From: Laura Gibbons
Sent: 02 January 2019 13:38
To: Planning.Responses
Cc: Simon Davis
Subject: RE: Planning Consultation on: Y/98/18/RES

Engineers Comments Regarding Surface Water Drainage

APPLICATION NO: Y/98/18/RES

Site Address: Land off Burndell Road Yapton

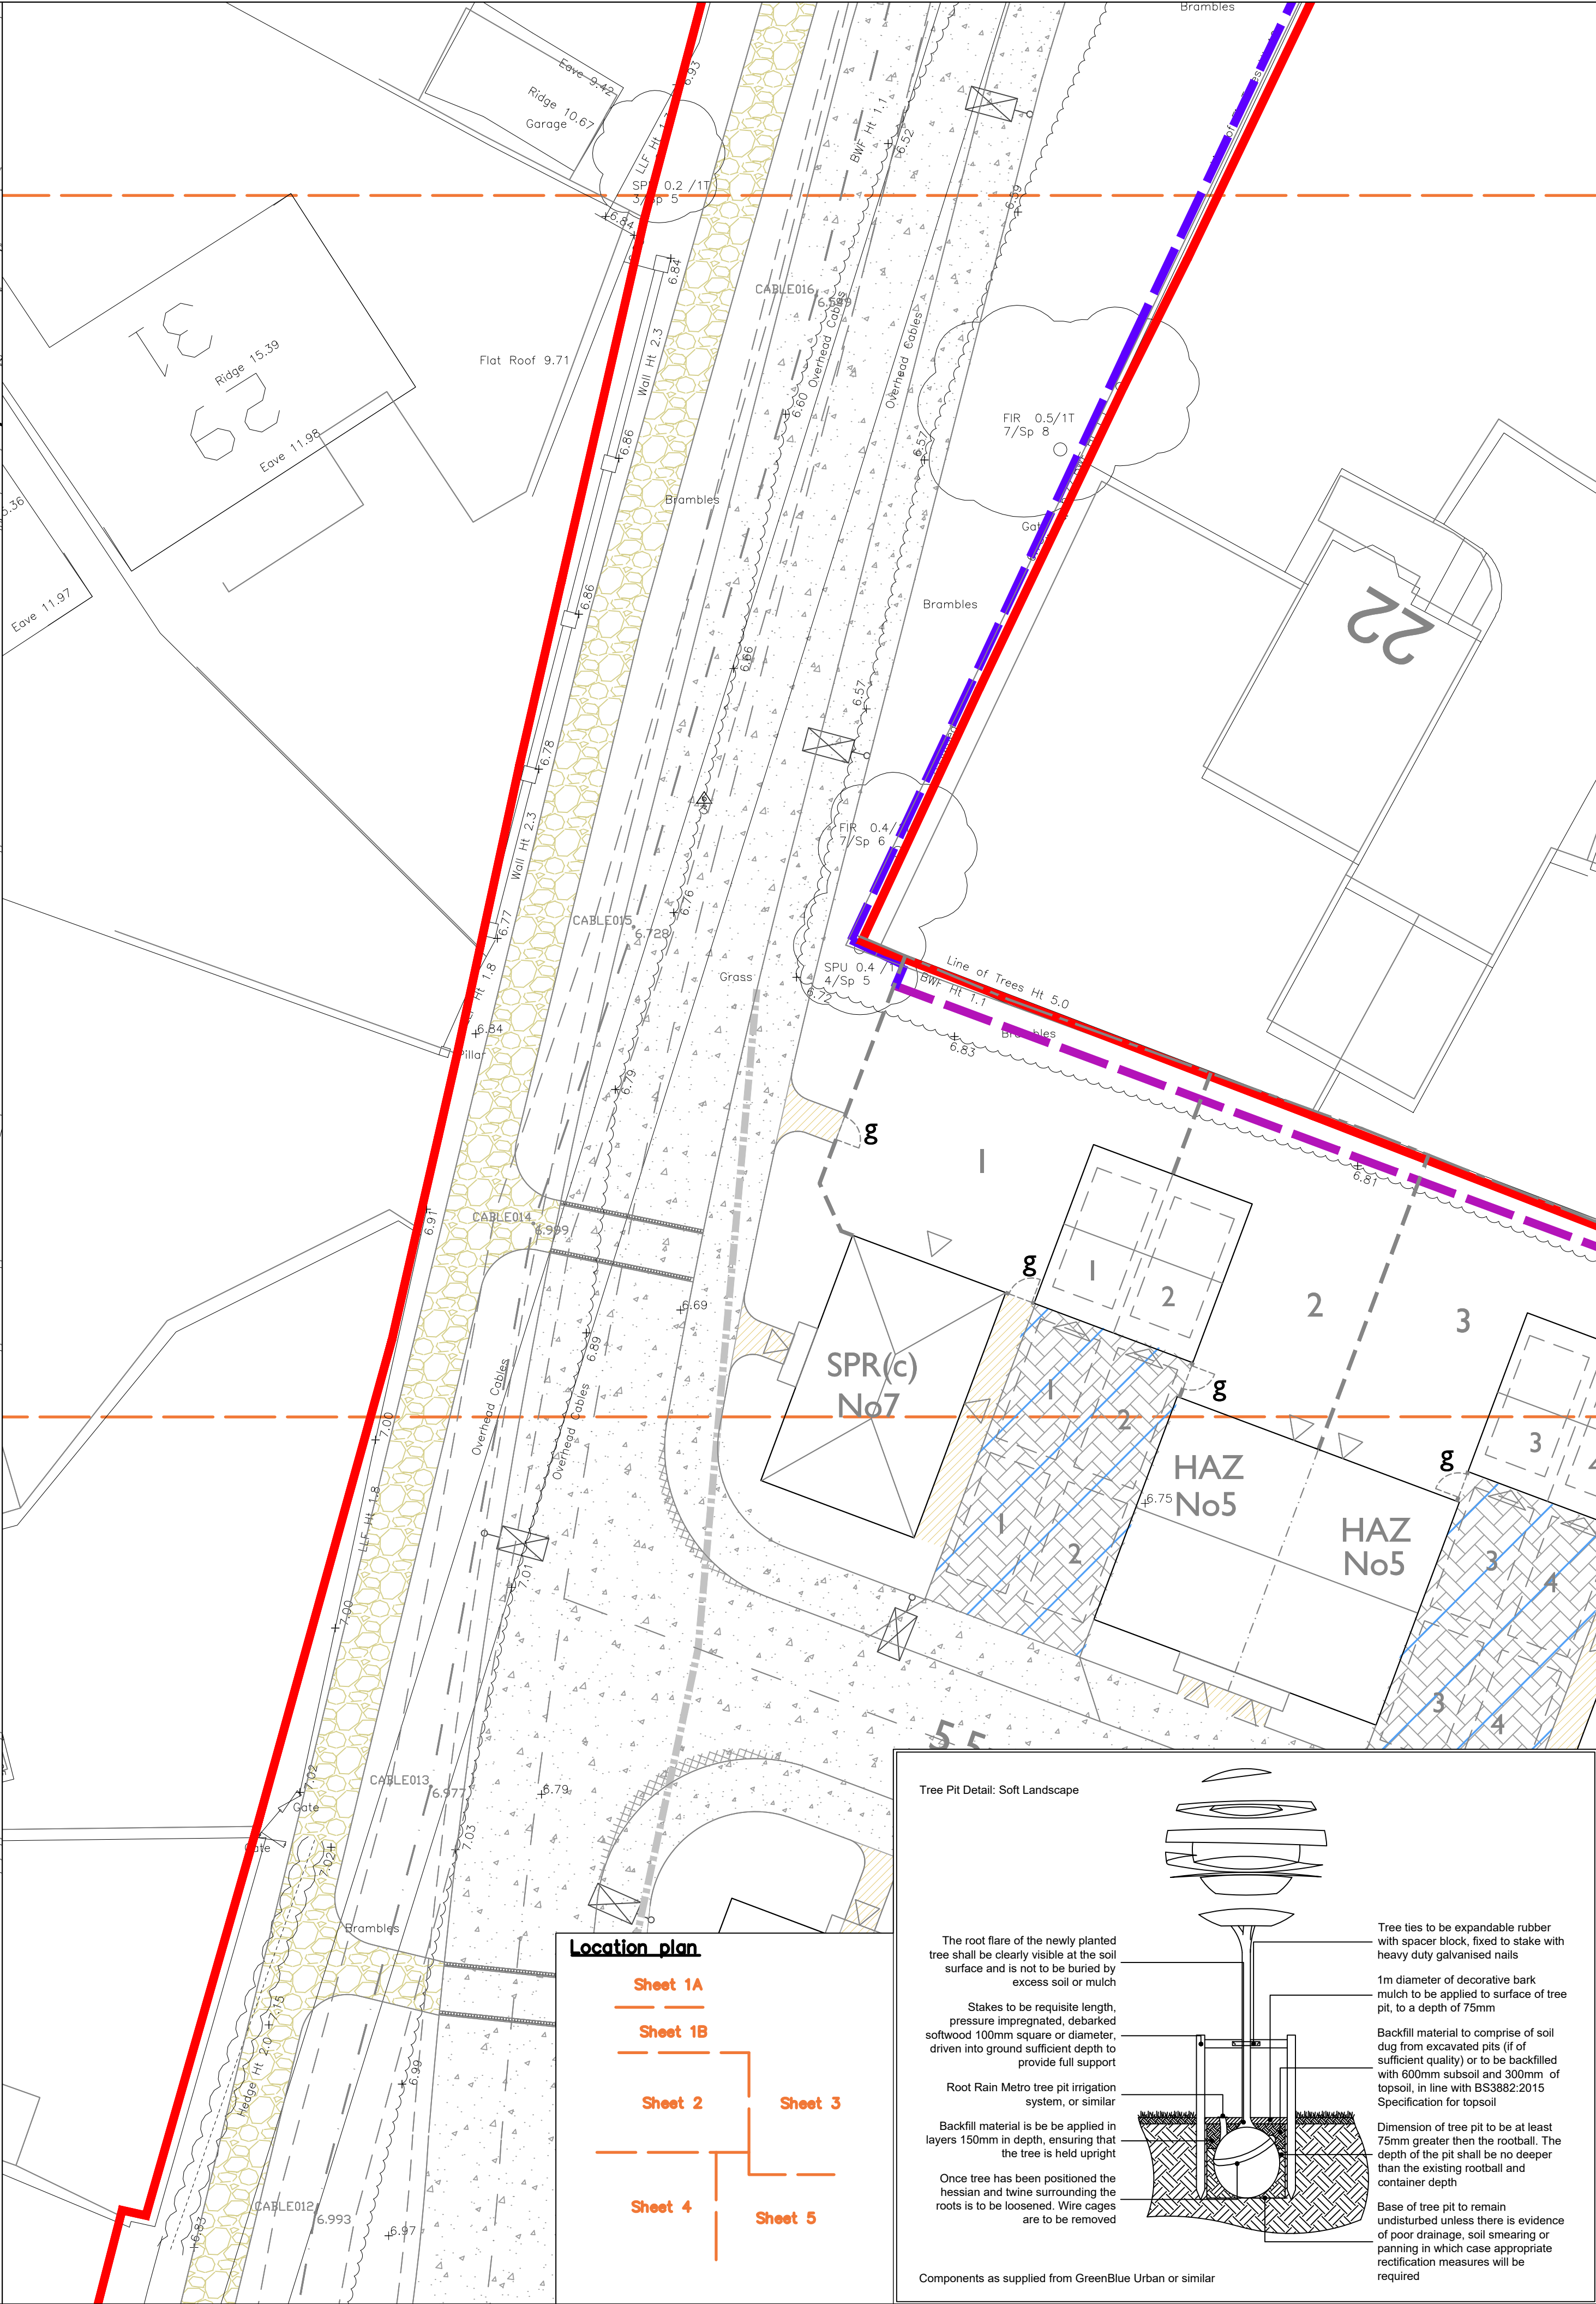
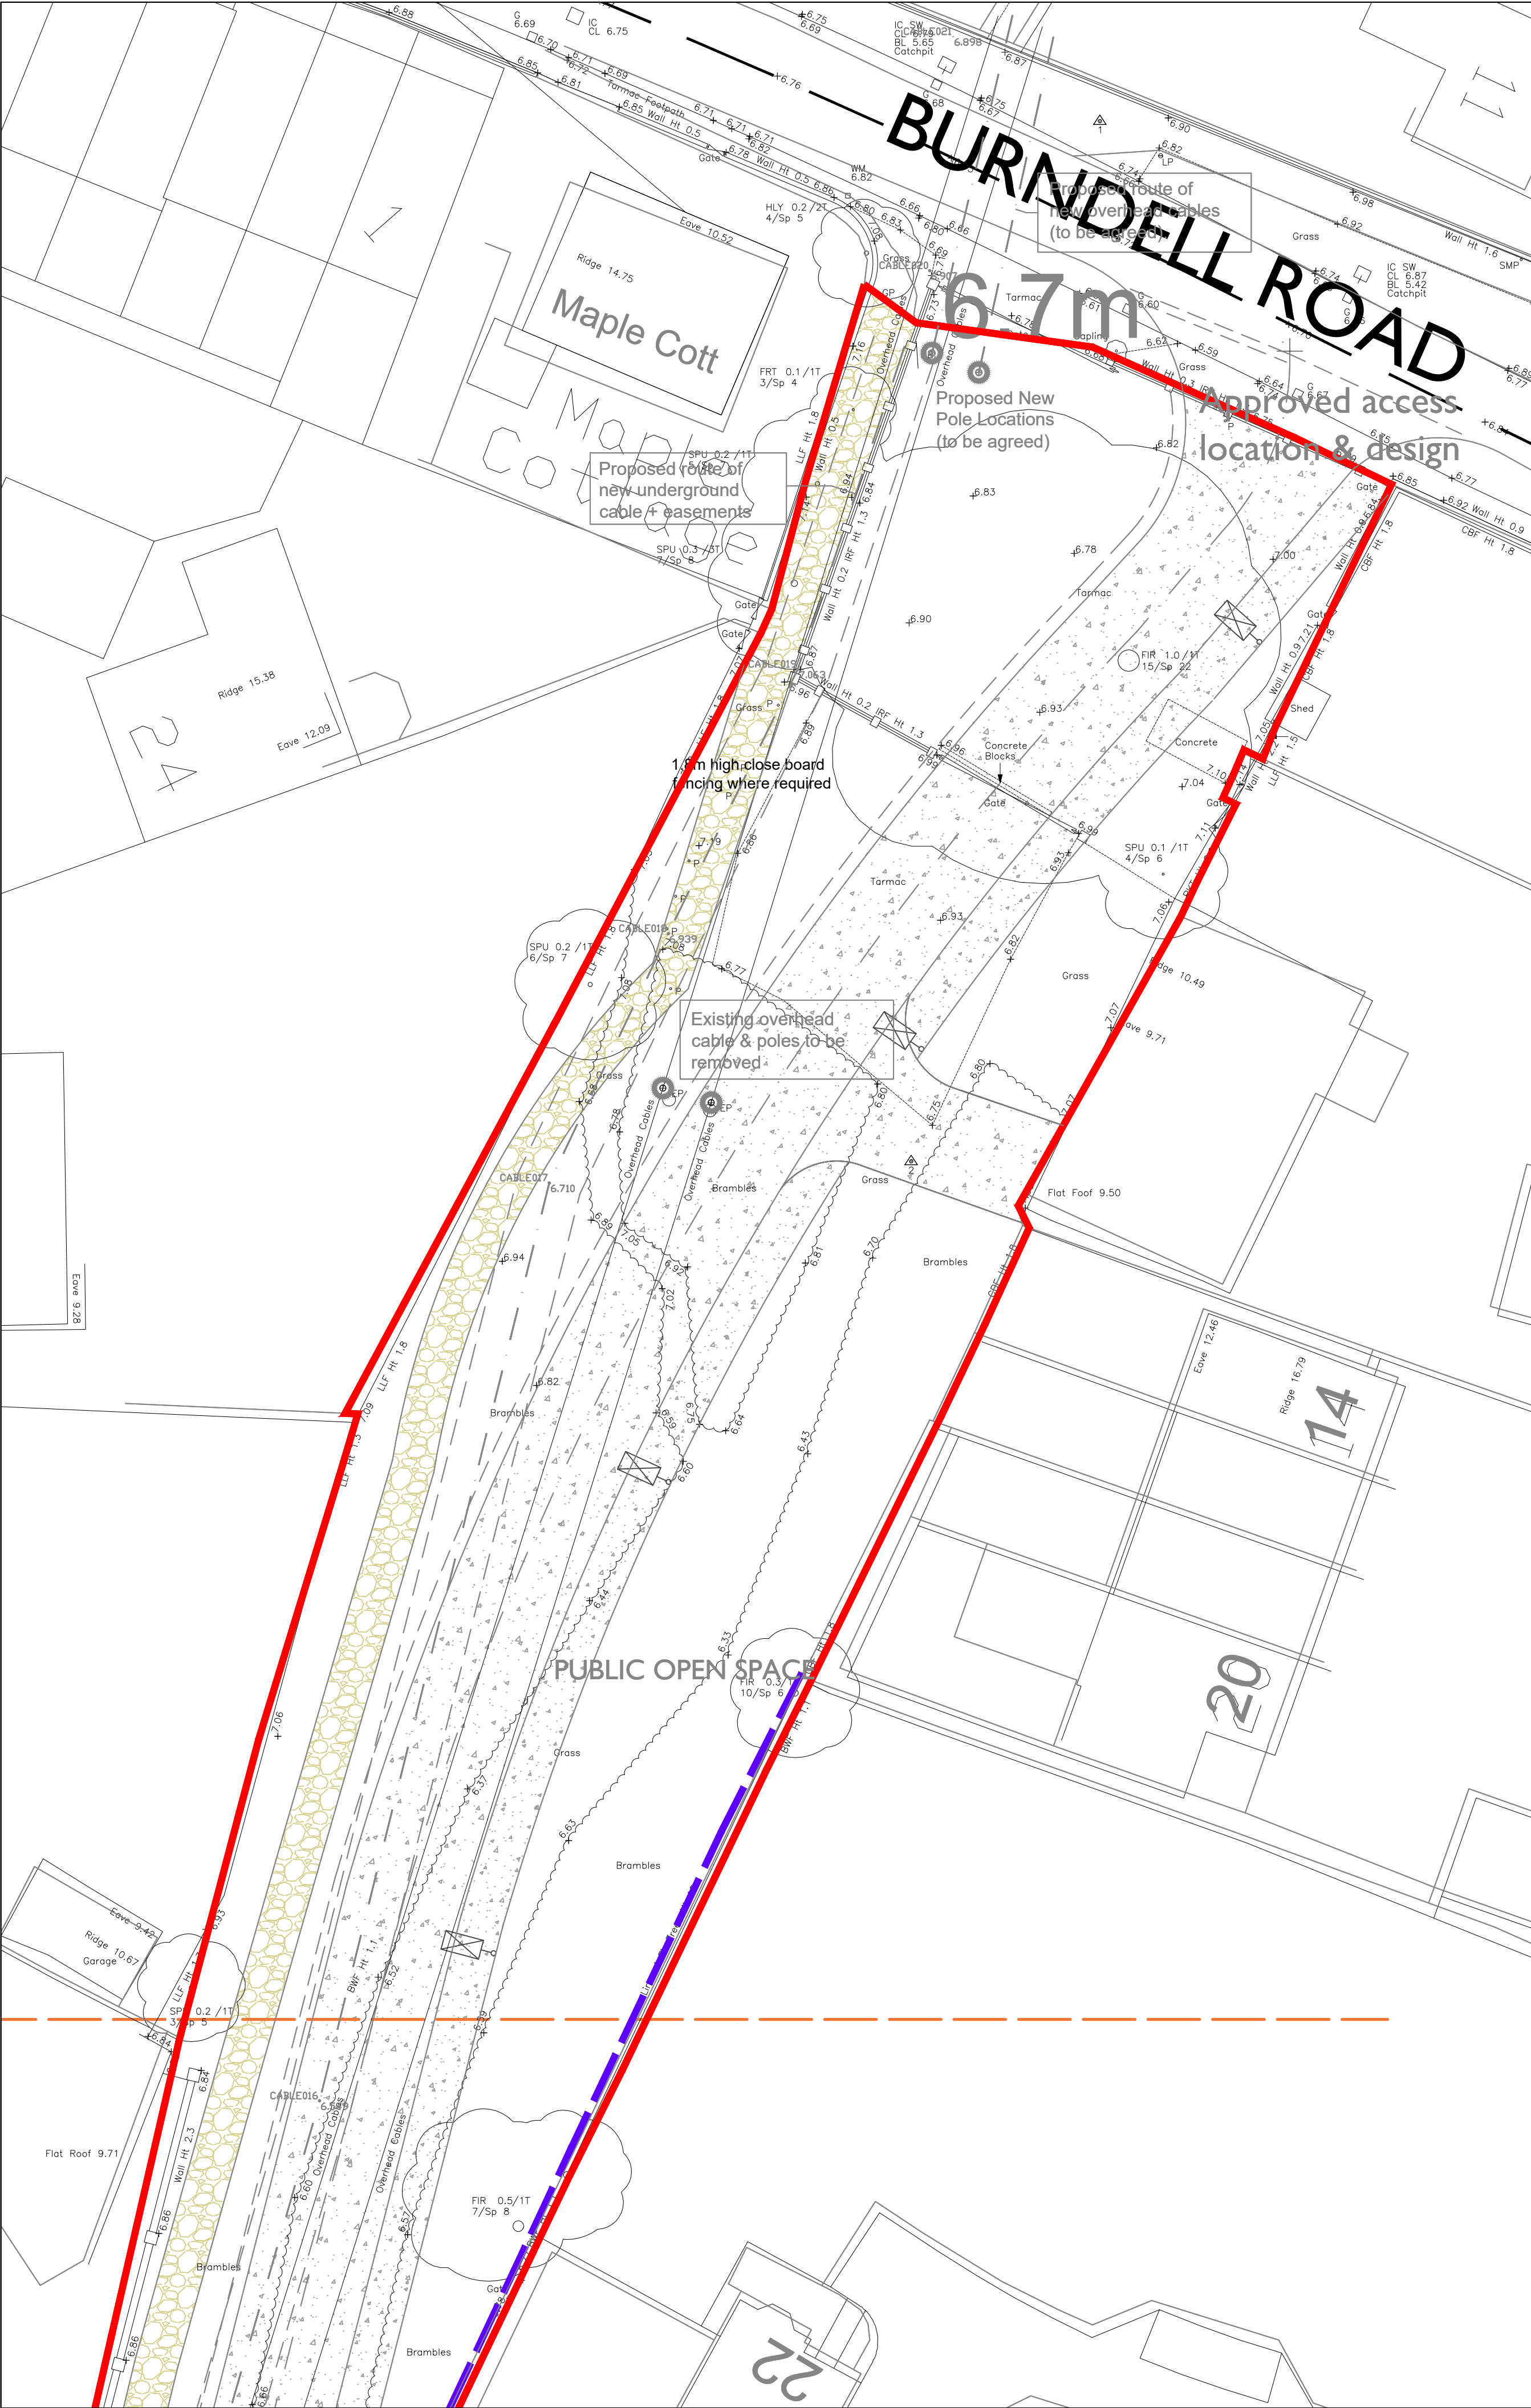
I would also like to raise my concerns regarding the proposed landscaping scheme. There are numerous trees located within close proximity to attenuation features and ordinary watercourses. The landscaping scheme needs to fully consider the surface water drainage scheme.
